November 04, 2022
Merrick Project No. 65121260

**Re: Chick-Fil-A/ Extend the Drive-thru
8110 San Pedro Dr. NE
Traffic Circulation Layout
Engineers/Architect's Stamp XX-XX-XX (C18-D042A)**

Merrick & Company has reviewed the comments dated October 28, 2022, regarding the Chick-fil-A development. The following summarizes Merrick's responses to the comments provided by the City of Albuquerque Development Review Services.

C1.1

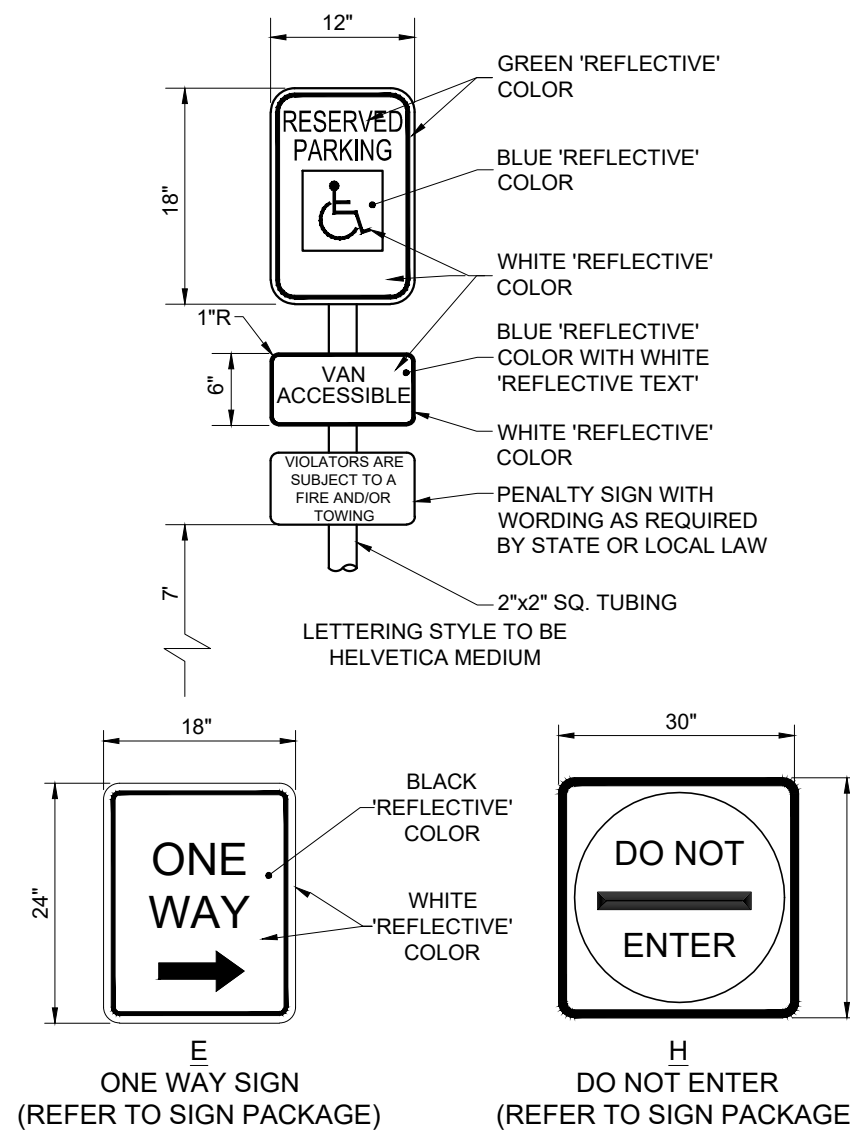
1. The traffic circulation layout must be stamped, signed, and dated by an engineer or architect licensed in the state of New Mexico.
[Response: Noted, the traffic circulation layout has been stamped, signed, and dated by an engineer licensed in the state of New Mexico.](#)

2. Due to removing the parking spaces at the northeast side of the site, please provide new parking calculation indicate that the available parking spaces still meet the IDO requirements.
[Response: The new parking calculations per the in effect 2021 IDO ANNUAL UPDATE – EFFECTIVE DRAFT JULY 2022 has been provided. The proposed development meets the required 8 spaces/1,000 sq. ft. GFA as required for a restaurant per Table 5-5-1 of the IDO.](#)

3. Due to removing the existing Bicycle Rack, List the number of Motorcycle and Bicycle parking spaces required by the IDO.
[Response: Per the IDO Table 5-5-5, the minimum required number of parking spaces for a non-residential use not listed within the table is 3 spaces or 10% of required off-street parking spaces, whichever is greater. The total number of required parking spaces is 35 spaces which equates to a total of 4 bicycle spaces required. Per IDO Table 5-5-4 the minimum required motorcycle parking spaces is 2. This has been added to the TCL.](#)

4. Shared access and shared parking agreement need to be provided with adjacent eastside property.
[Response: Per our phone conversation on 11/4/2022 the 27 parking spaces to the north labeled as lease parking spaces has been revised to depict standard parking spaces within the property and no shared parking agreement is required. The parking table has been revised to reflect this. Since the parking within the property meets the required parking counts the parking with the adjacent eastside property will not be counted towards the Site's parking counts and a shared parking agreement will not be required.](#)

5. Provide the angle and the dimensions for all the existing angled parking spaces.
Response: The angle and dimensions for all existing and angled parking spaces has been added.

6. The ADA accessible parking sign must have the required language per 66-7-352.4C NMSA 1978 **“Violators Are Subject to a Fine and/or Towing.”** Please call out detail and location of signs.

7. The ADA access aisles shall have the words **“NO PARKING”** in capital letters, each of which shall be at least one foot high and at least two inches wide, placed at the rear of the parking space so as to be close to where an adjacent vehicle’s rear tire would be placed. (66-1-4.1.B NMSA 1978)

Response: A **“NO PARKING”** graphic has been called out to be provided with the proposed improvements.
8. Provide **“STOP”** and **“Do Not Enter”** signage and pavement marking at the south east side of the drive-thru lanes.

10. Motorcycle parking spaces shall be designated by its own conspicuously posted upright sign, either free-standing or wall mounted per the zoning code.

Response: Motorcycle parking spaces have been added as well as a sign to designate motorcycle only parking.
11. The pavement marking **“MC”** should be shown in the opposite direction for motorcycles entering the parking space.

14. A 1-foot clear zone around the bicycle parking stall shall be provided.
Response: A 1-foot clear zone around the bicycle parking stalls has been provided.

15. Bicycle parking spaces shall be at least 6 feet long and 2 feet wide.
Response: Parking stalls have been provided with a minimum of 6 feet long and 2 feet wide.

16. Please specify the City Standard Drawing Number when applicable.
Response: Comment Noted, City Standard Drawing Number referenced where applicable.
17. Add a note stating "All broken or cracked sidewalk must be replaced with sidewalk and curb & gutter." A build note must be provided referring to the appropriate City Standard drawing.

Response: Annotation callouts have been added to the plan at the appropriate locations requiring that a sign meeting the above criteria is in place with the proposed improvements.

Response: Existing **“STOP”** graphic, bar, and sign called out to remain. Proposed **“Do Not Enter”** graphic and sign added to plan.
9. ADA curb ramps must be updated to current standards and have truncated domes installed.

Response: No change has been made, all existing ADA curb ramps within the property are up to city standards and contain truncated domes installed. All proposed ADA ramps are designed per the city standards and will contain truncated domes.

Response: The pavement marking **“MC”** has been added in the opposite direction for motorcycles entering the parking space.
12. All bicycle racks shall be designed according to the following guidelines:

Response: A note has been added to the TCL stating "All broken or cracked sidewalk must be replaced with sidewalk and curb & gutter; Contractor to use city of Albuquerque standard details 2415c & 2430 for replacement."
